From: Anita Gardner
Sent: 26 April 2012 10:18
To: Planning.Responses
Subject: FW: The Old Barn - Ferring - Application No. FG/6/12 & FG/4/12/L

RE: The Old Barn - Ferring - Application No. FG/6/12 & FG/4/12/L

Further to yesterday's telephone discussion, please find attachments with Febo Designs revised drawings No's 3214-006 rev C, 3214-009 Rev E, 3214-010 Rev E and 3214-011 Rev D.

DRAWING NO.	DRAWN	SCALE	DATE	REV.
3214-006	AF	1:100 A1	April /12	C

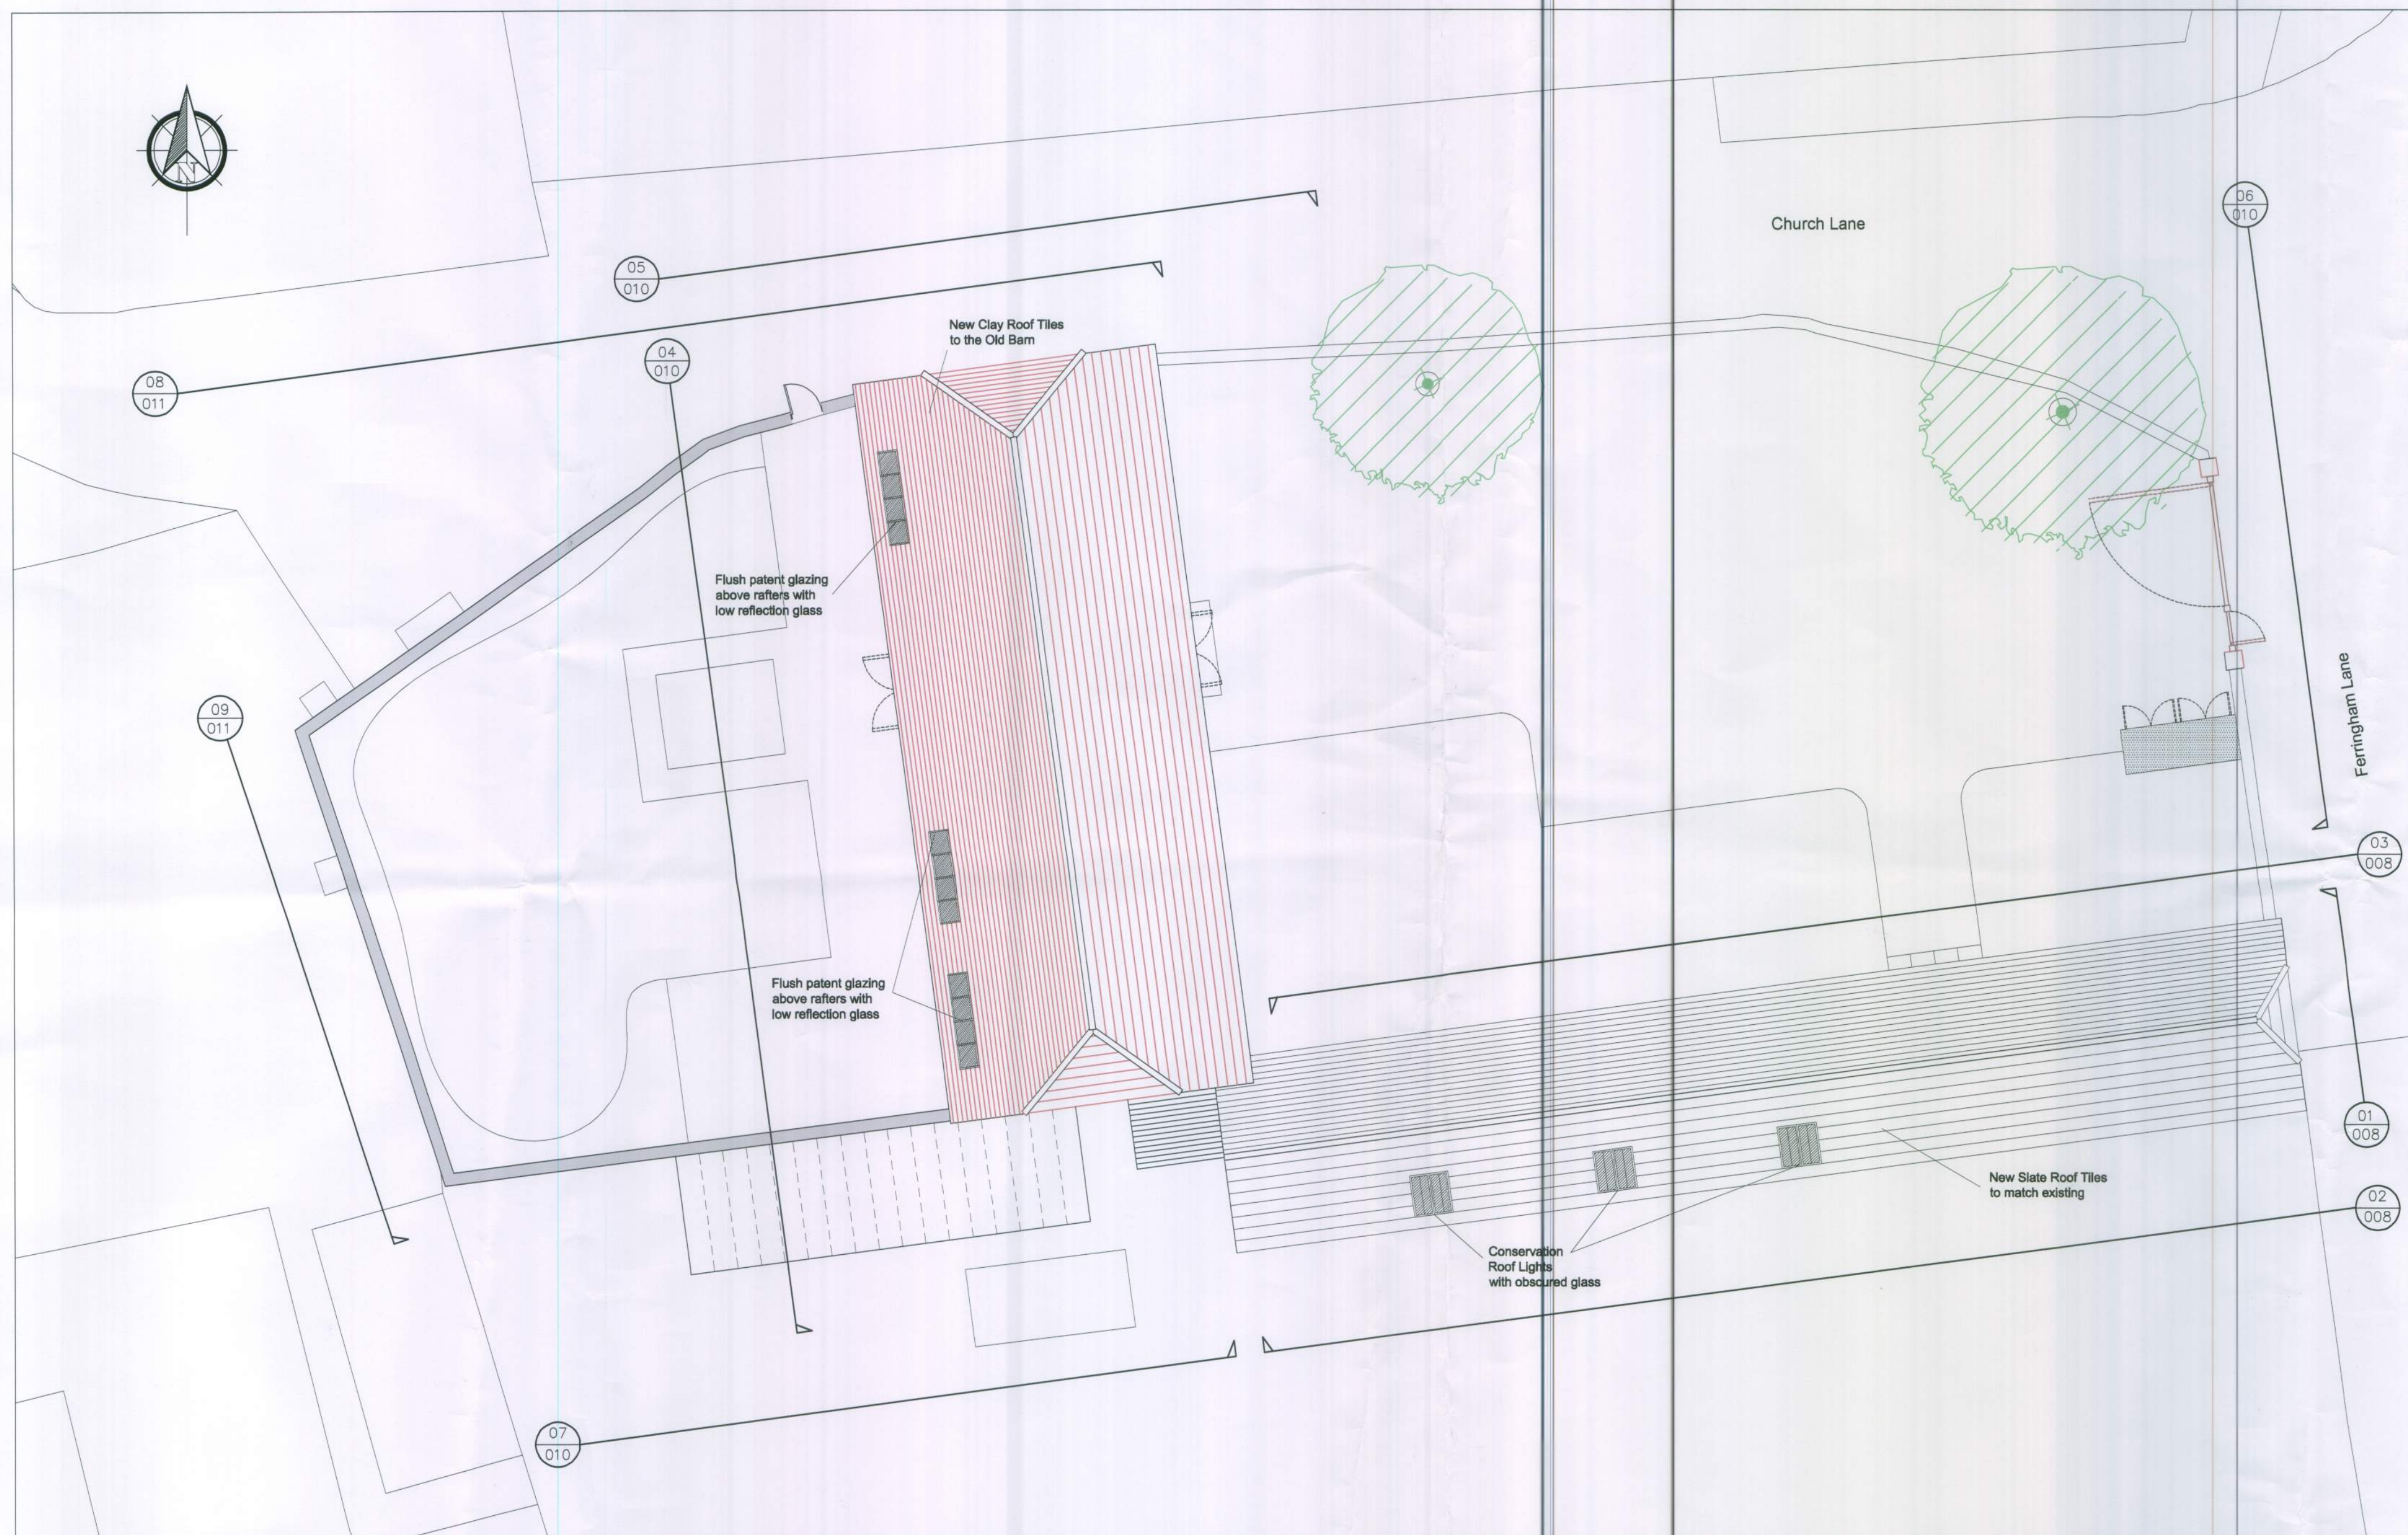
1. The Patent Glazing over the west entrance has been removed
2. The internal glazing to Bedroom 2 has been extended
3. The Study's partitions have been changed from solid to glazed construction

With regards to the profile and detail of the proposed Patent Glazing to the west side of the roof, we are happy if these items are conditioned to approved detail by ADC and if the proposals are not satisfactory, we are also happy to change them to conservation rooflights.

Further to our conversation today I can confirm that the amendments made here are acceptable on the basis that the glazing detail will be agreed by condition.
